# Oxley Highway to Kempsey

Upgrading the Pacific Highway  
Environmental assessment  
submissions report

Submissions Report

14 March 2011

Figure 1 Proposed Yarrabee Road Arrangement

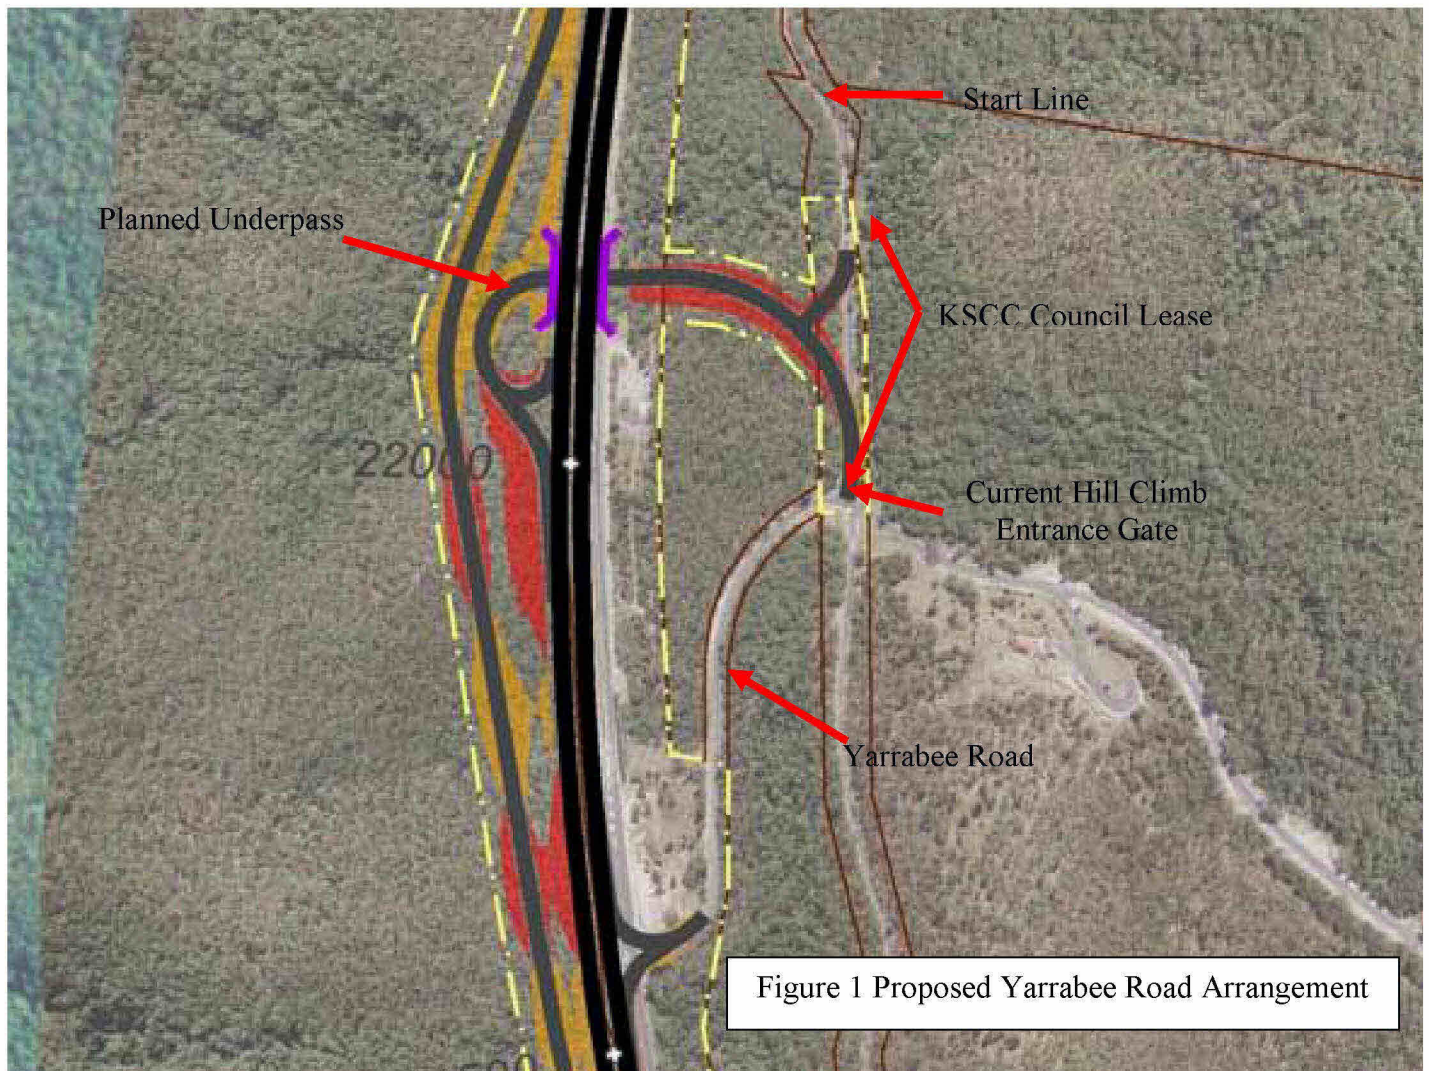
- 5) One community submission advised that the proposed concept design for the Yarrabee Road traffic arrangement will impact the operation of major events at the Hillclimb track.

- 5) The potential impacts on the Hillclimb track were considered during the preparation of the environmental assessment and the concept design. However, we note the advice from the respondent regarding the potential impacts on the operation of larger events at the Hillclimb track. The RTA would investigate the potential to adjust the alignment of Yarrabee Road during the detailed design phase. Further consideration would be given to the level of impact on the track and the most suitable adjustment options and if applicable, negotiations undertaken in accordance with the requirements of the *Land Acquisition (Just Terms and Compensation) Act 1991*.
